SCOPING OPINION:

Proposed A46 Coventry Junctions (Walsgrave)

Case Reference: TR010066

10 August 2023

DRAWING NUMBER
HE604820-OIL-LDC-00-DR-CH-26000

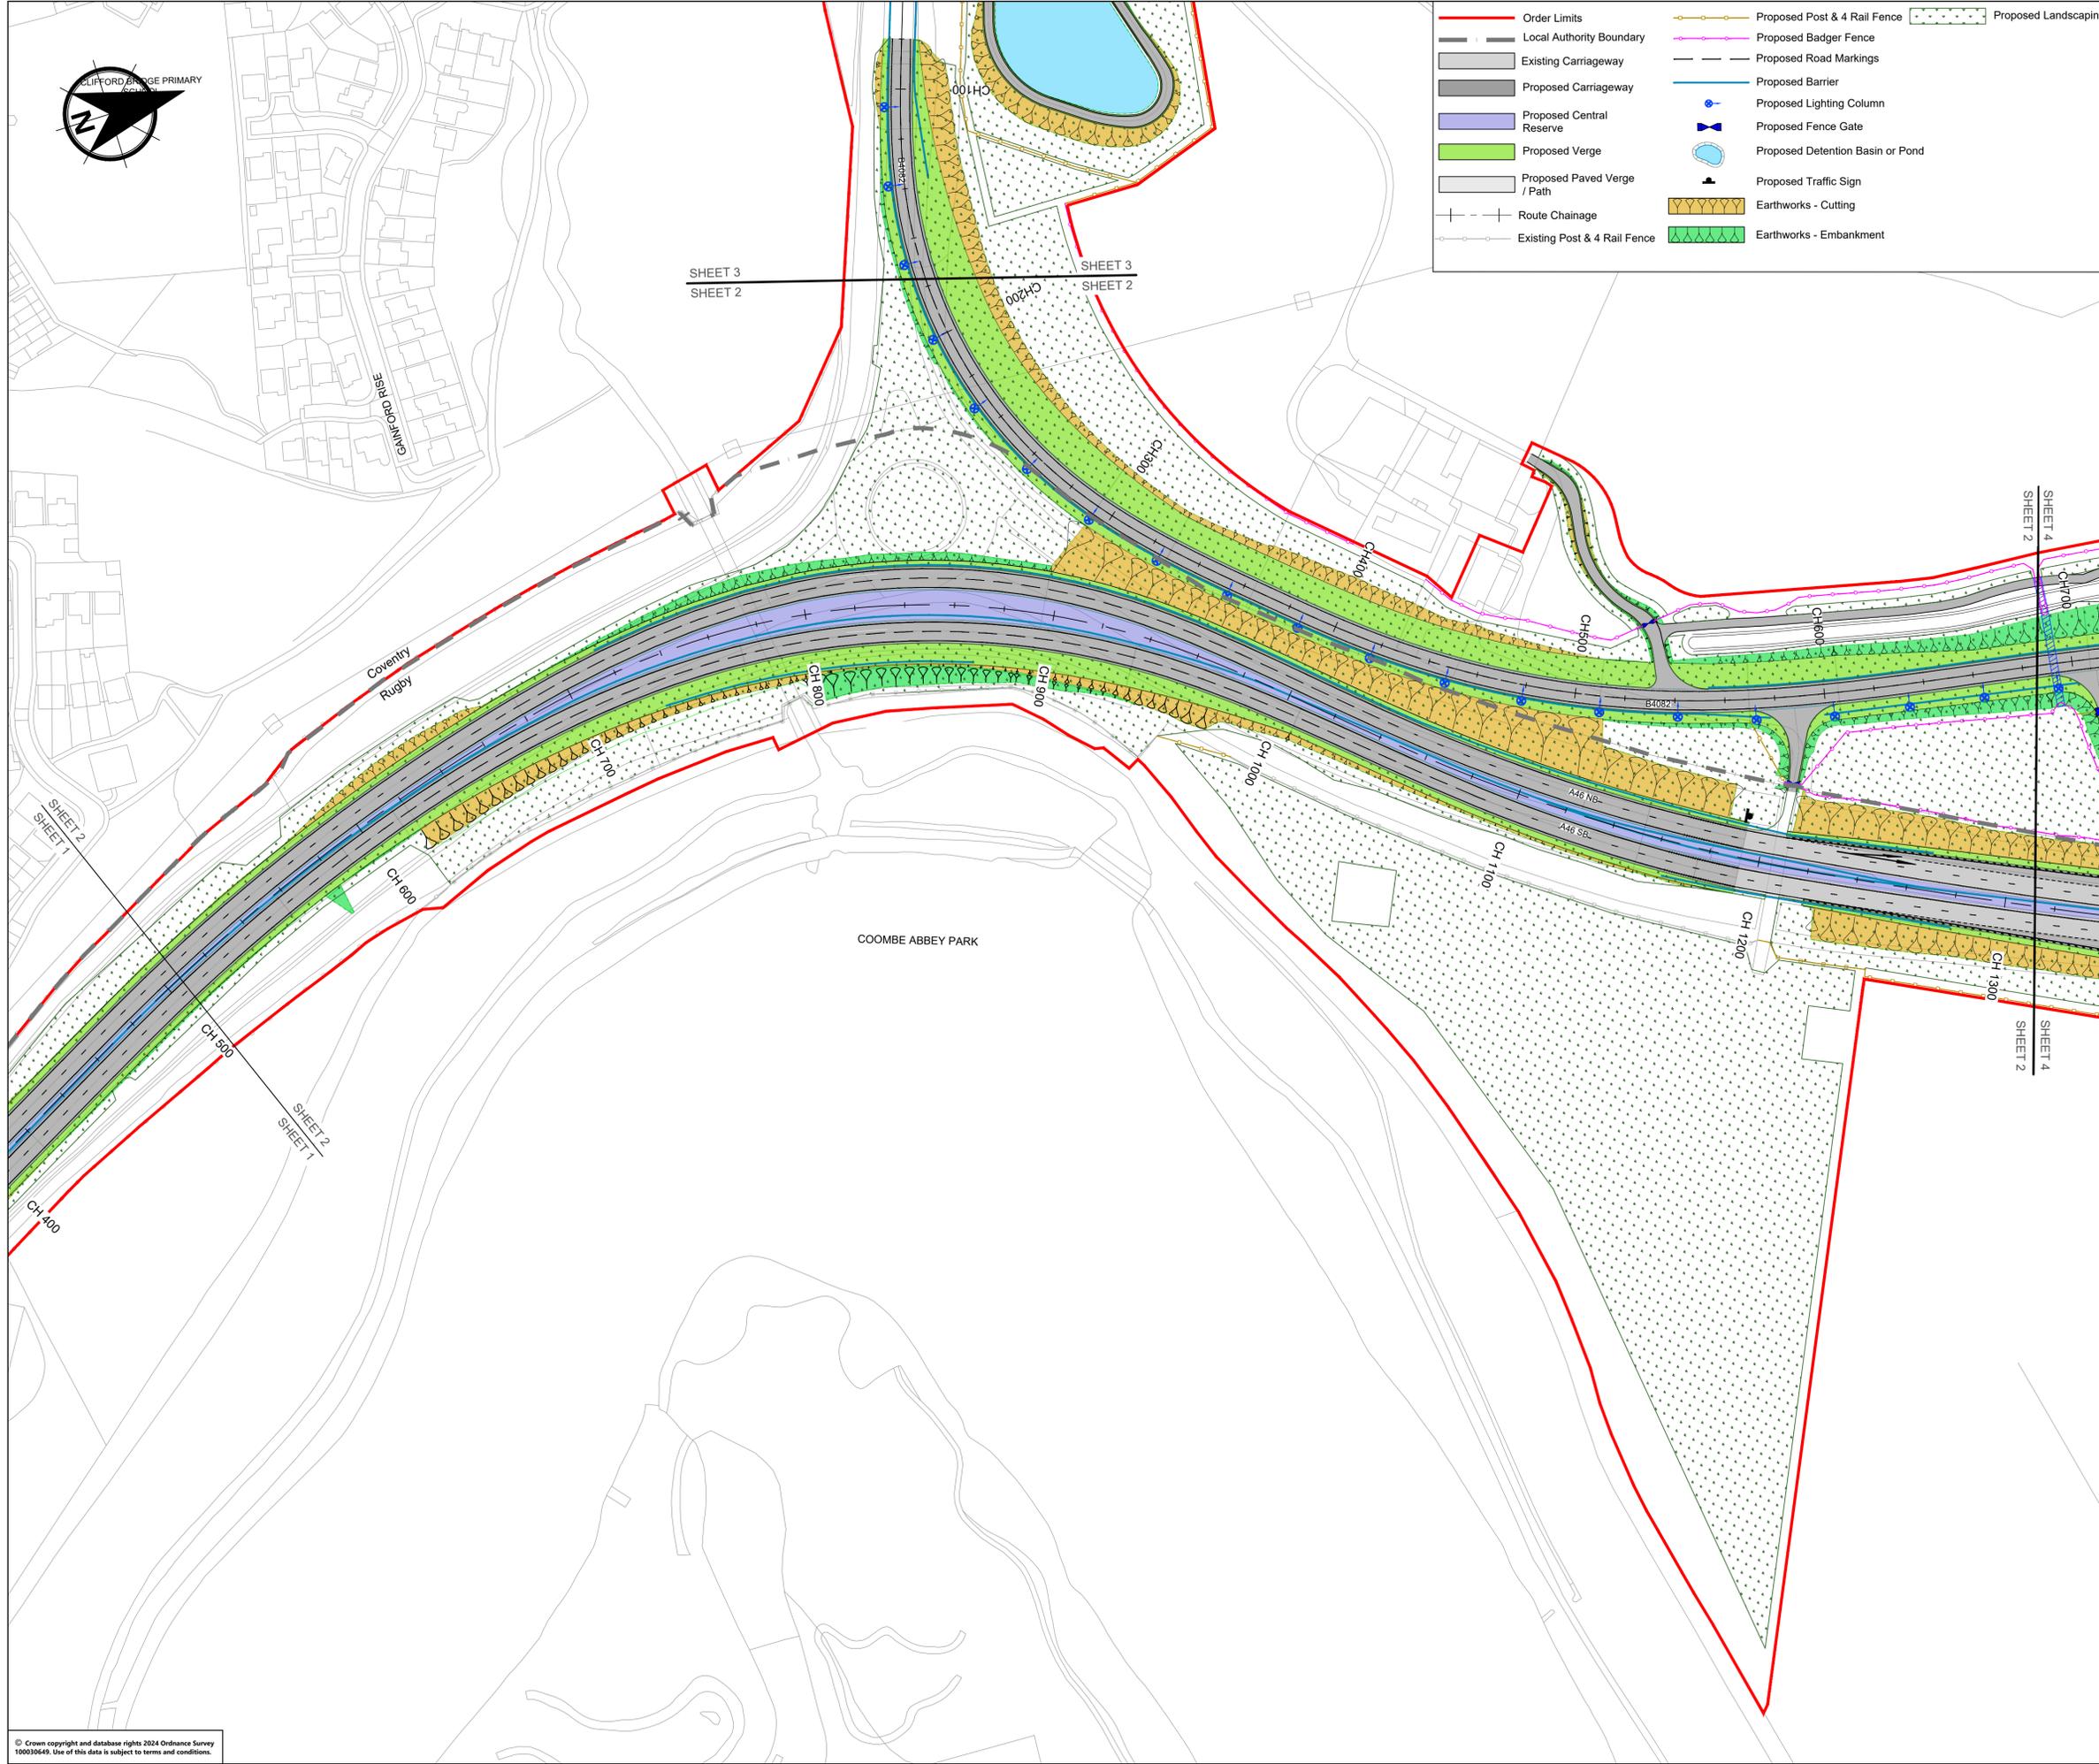
2.1.15	Appendix A	General Arrangements Drawing – Design Extents	<p>General Arrangements Drawing Sheet 1 indicates that the southern extent of the design extents has been shortened to avoid the Brinklow Road bridge. However, the same consideration has not been given to the northern extent which includes the Farber Road bridge despite there not appearing to be any planned works to the carriageway, verge or earthworks, and this bridge containing a Public Right of Way (PRoW).</p> <p>The ES should include, within the project description or assessment of alternatives, why the scheme is required to include the Farber Road Bridge.</p>
